**Consultation Response from KC,  
Highways Development Management**  
**2023/91702 adj 60, Lister Street, Moldgreen, Huddersfield, HD5 8BB**  
**Erection of dwelling**  
**Date Responded: 06/09/2023.**  
**Responding Officer: D. Stainsby**  
**Responding Ref: K11-1SW/11**

Site Plan
1: 200

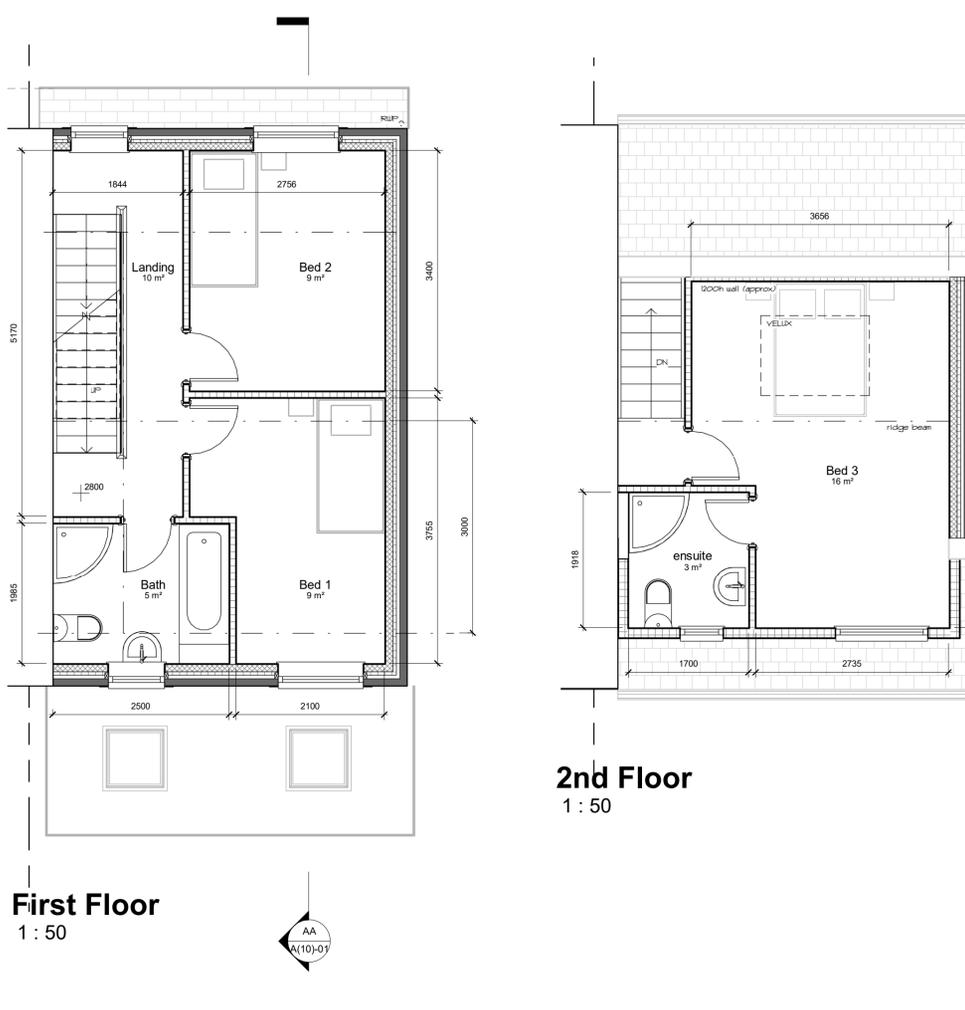
Objection. The proposal is for a 3 bedroomed dwelling with no off street parking and is therefore considered unacceptable.

The proposal is for a 3 bedroomed dwelling with no off street parking and is therefore not in accordance with local guidance which recommends that for a 3-bedroom dwelling a minimum of two off street car parking spaces should be provided.

Lister Street and Douglas Avenue are residential streets where most properties do not have off street parking and on street parking is already at a premium.

Any additional parking would only exacerbate the existing situation to the detriment of road safety in the area.

As a result, I object to the application due to the lack of adequate parking and the road safety concerns that this will cause.
